From: Anita Gardner <Anita.Gardner@arun.gov.uk>
Sent: 05 October 2020 13:08
To: Planning.Responses <Planning.Responses@arun.gov.uk>
Subject: FW: F/21/20/DOC Wicks Farm

I have summarised my comments below in respect to the outstanding issues;

The following link will allow a download of the drawings as noted on the attached drawing issue register together with the updated Reservoir Calculations and Management and Maintenance Plan. For ease of reference I have noted our responses in green below to the latest comments.

MANHOLE SW-06
WITH HYDROBRAKE
(Scale 1:25)

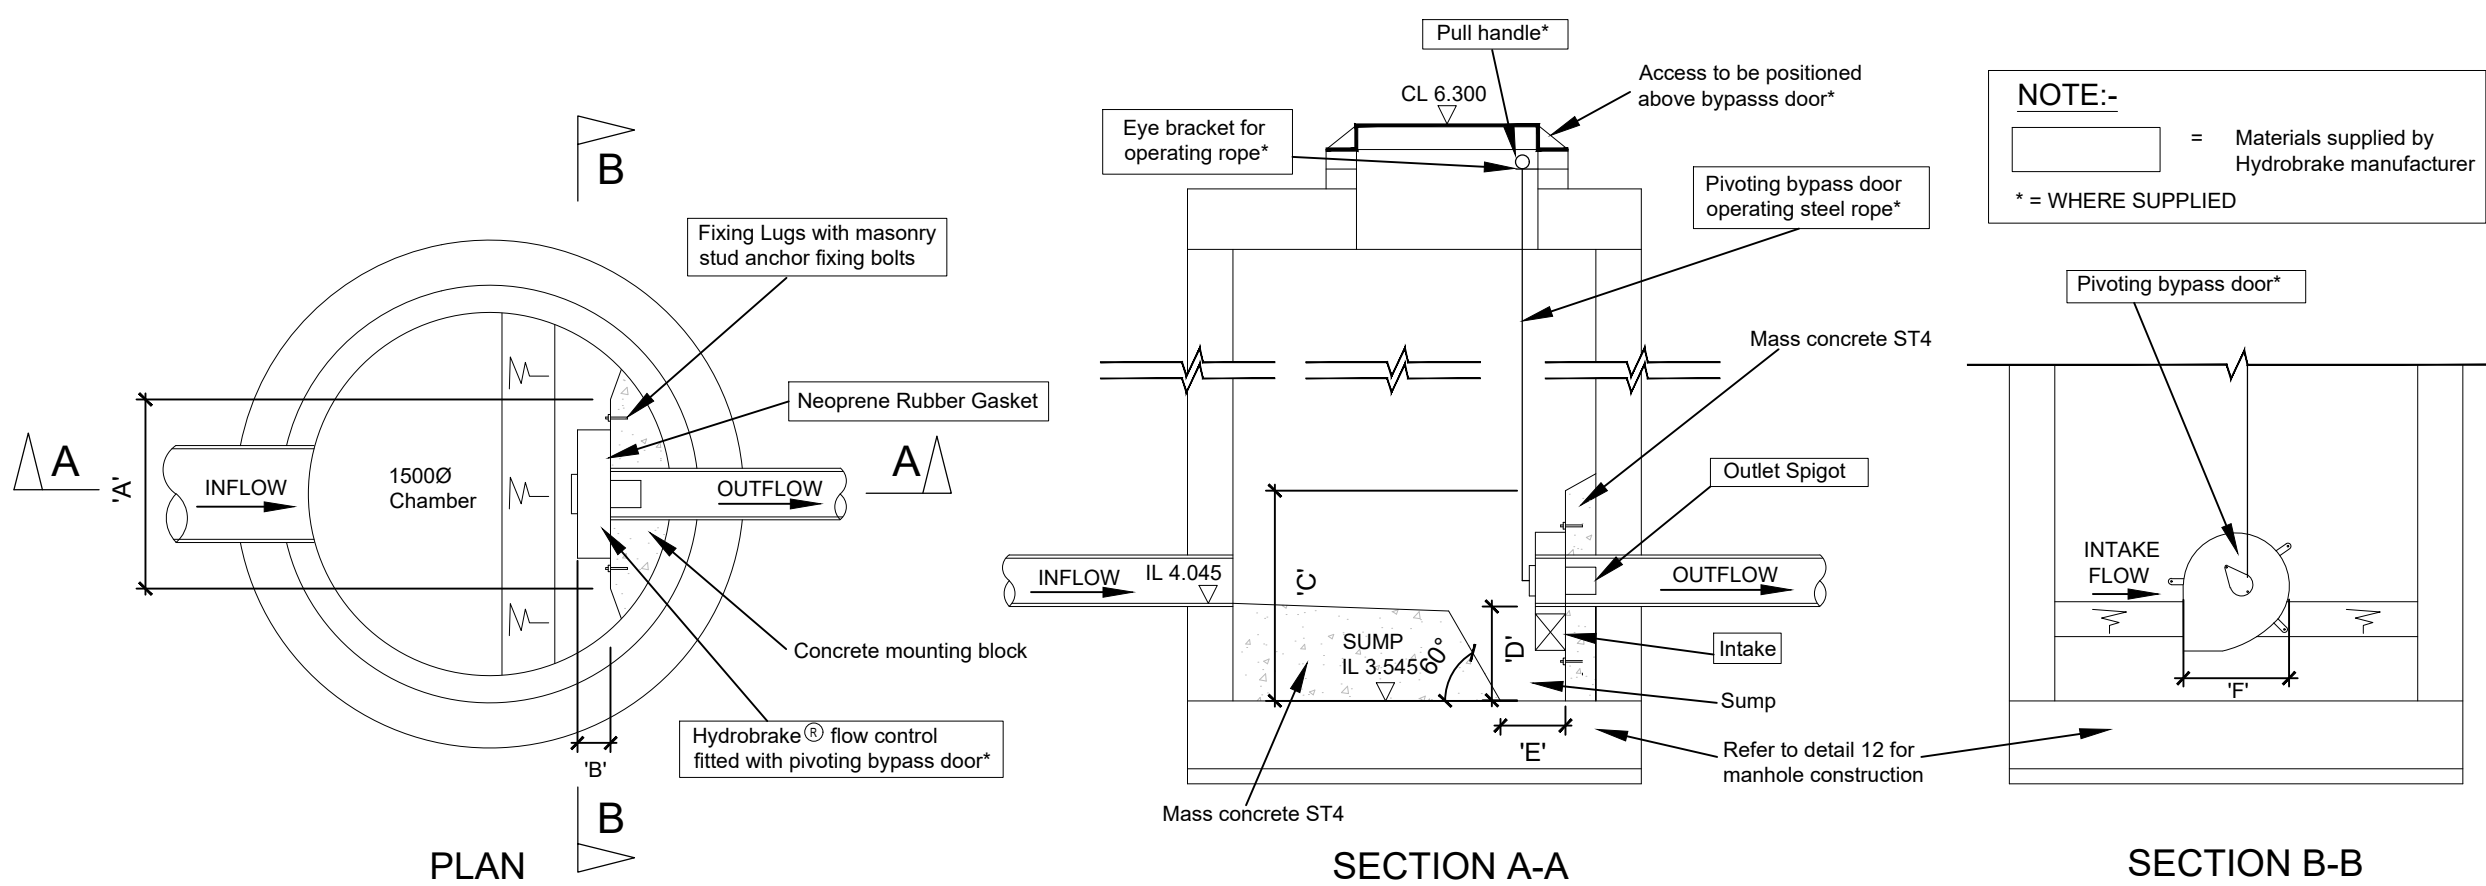
6. **Specify gradient between overflow pipe and hydrobrake chamber.** The gradient is 1 in 44 and is included on drawing 22E. ok. Noted.
7. **Provide hydrobrake chamber construction detail.** Noted and included in the link above on drawing 52B. Cover level and invert level are relevant to SW-07 – I would suggest just adding a note – ie. refer to the relevant layout drawing. Whilst the chamber construction details make reference to the details shown on 'manhole construction no.12 drawing', please specifically mention a granolithic finish to the benching. The Hydrobrake detail has been amended to say refer to layout Drawings 22 and 24 for Cover Levels, Invert Levels and Sump Levels. The note regarding the manhole construction and granolithic benching finish updated on detail also. See Drawing 52C.

17. Provide hydrobrake chamber construction detail. Noted, included in the link above on drawing 52B. See item 7 above – similar comment applies. Noted. See my response to item 7 above.

ALTHON HEADWALL R10CA
(Scale 1:20)

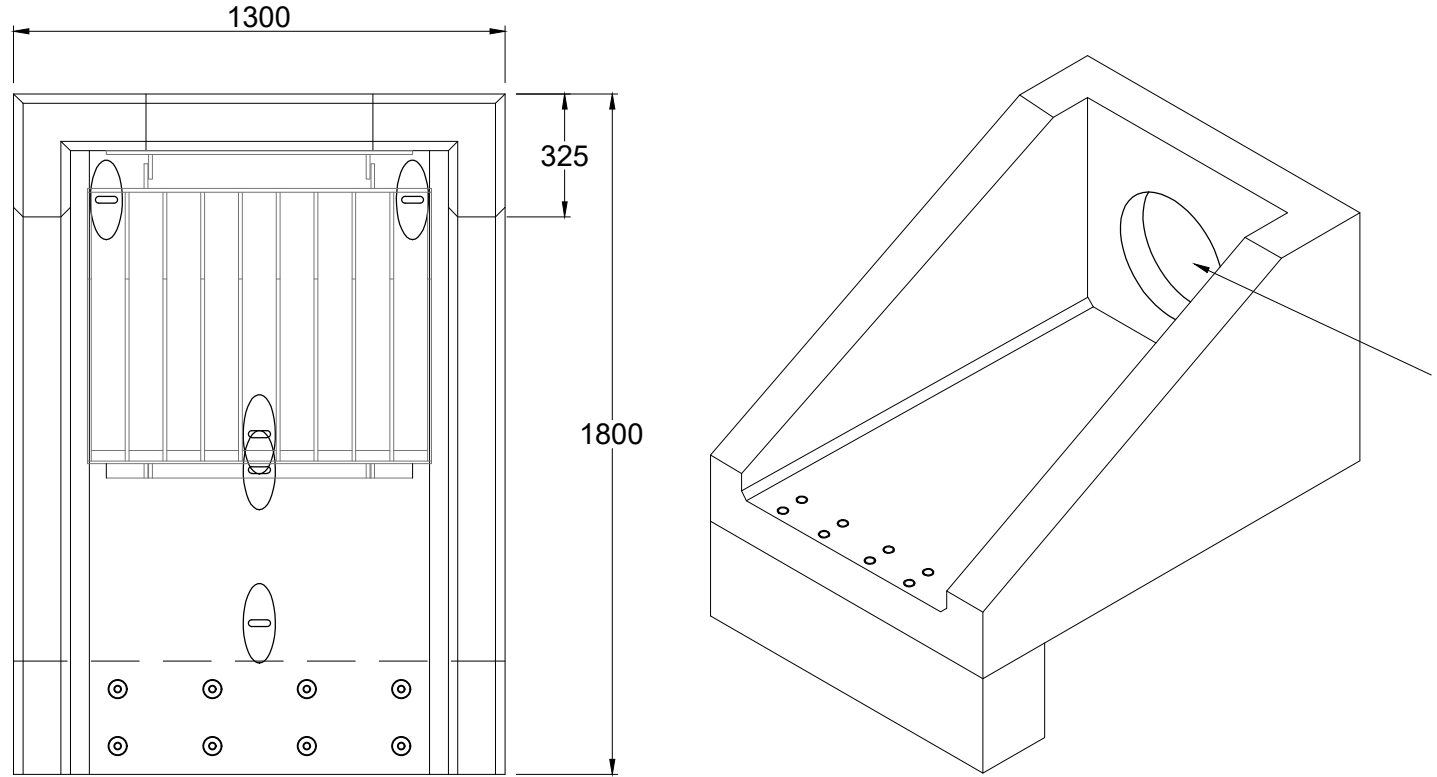
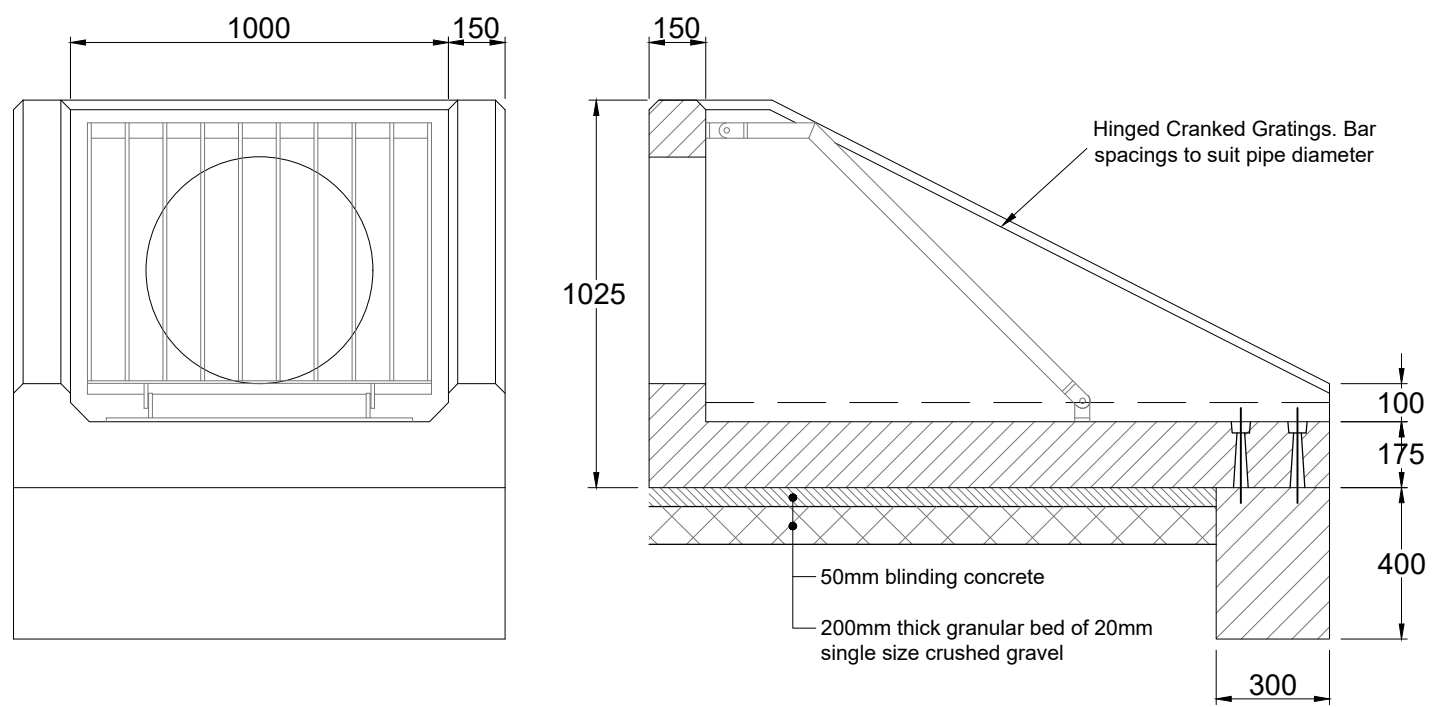
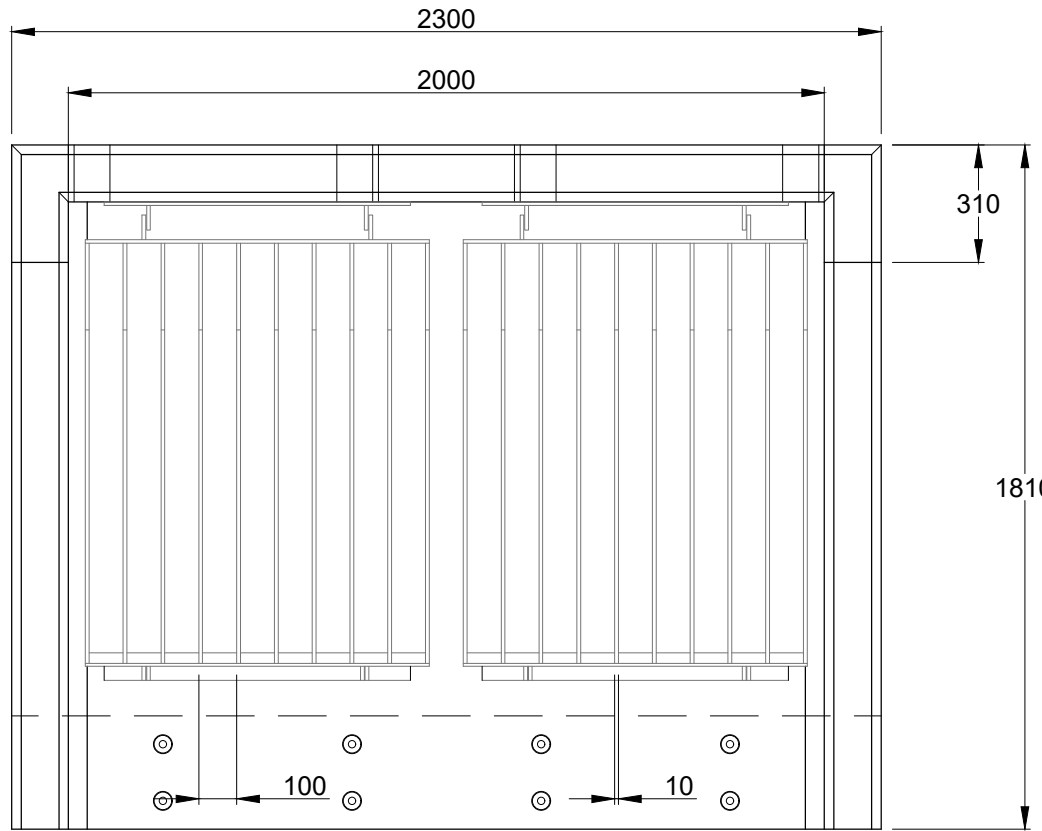
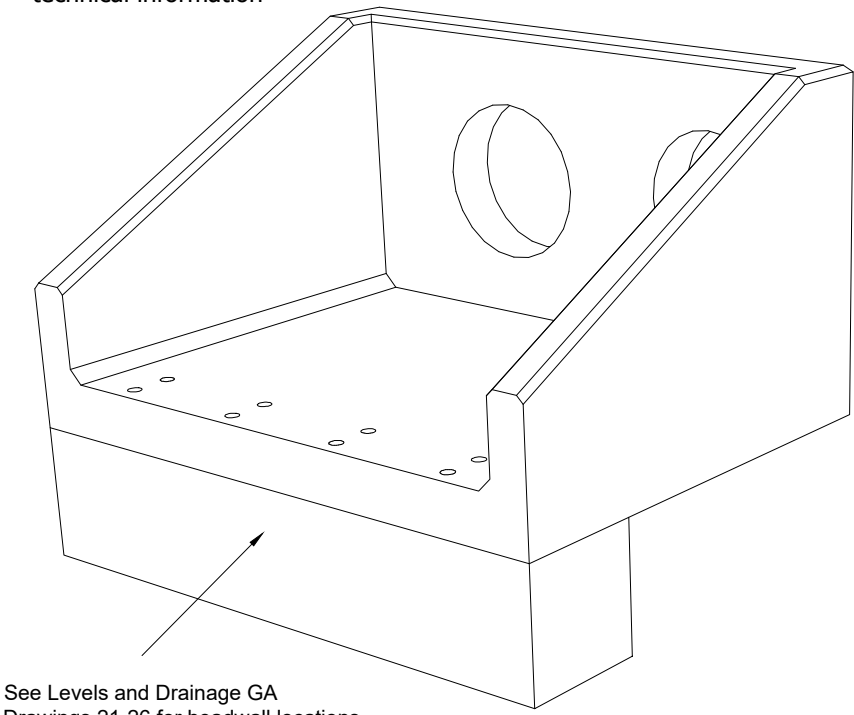
5. **Overflow pipe from reservoir provide headwall with cranked grille with bar spacings to suit 150mm diameter pipe. Include construction detail.** Detail of Althon Headwall R10CA with cranked grill and installation instructions provided on 13 July 2020 and are included in the link above on drawing 53. Ok. Noted.

LONG SECTION - WESTERN DITCH
(Horizontal Scale 1:500 / Vertical Scale 1:125)

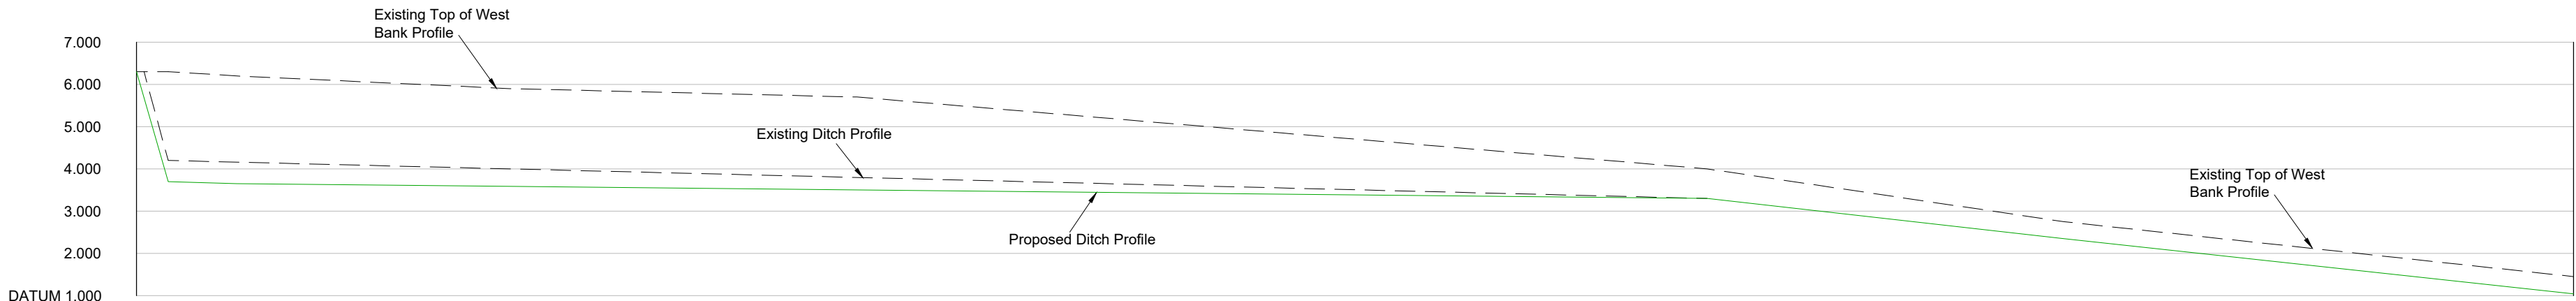
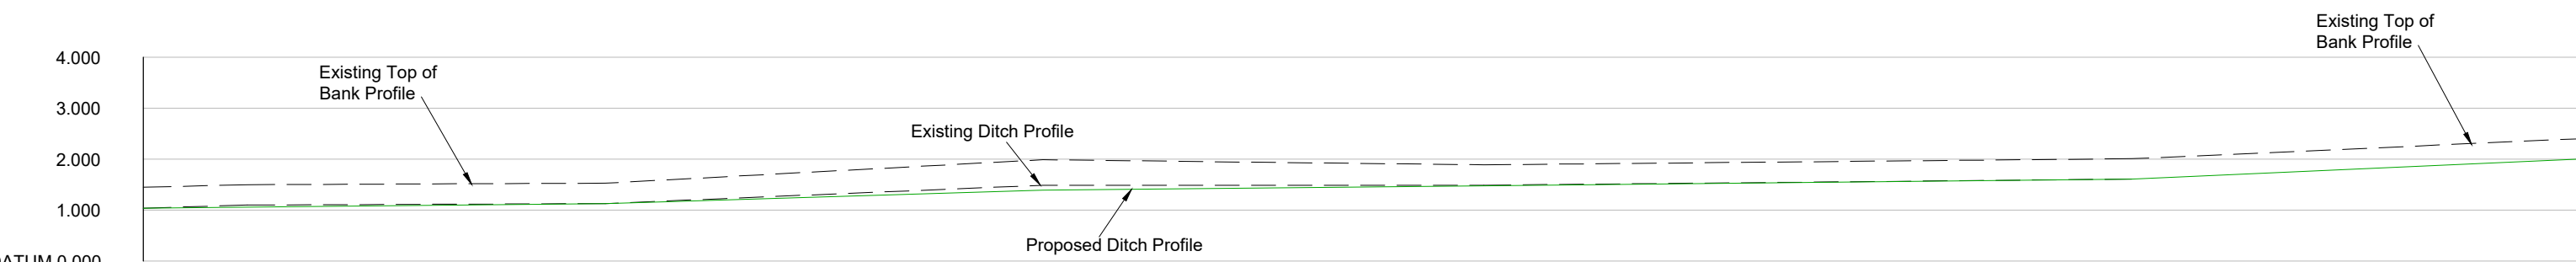
11. **Provide longitudinal section showing existing and proposed bed levels.** This is an existing ditch, we have provided the existing levels on the submitted drawings, long section is included in the above link on drawing 70. Ok. Noted.
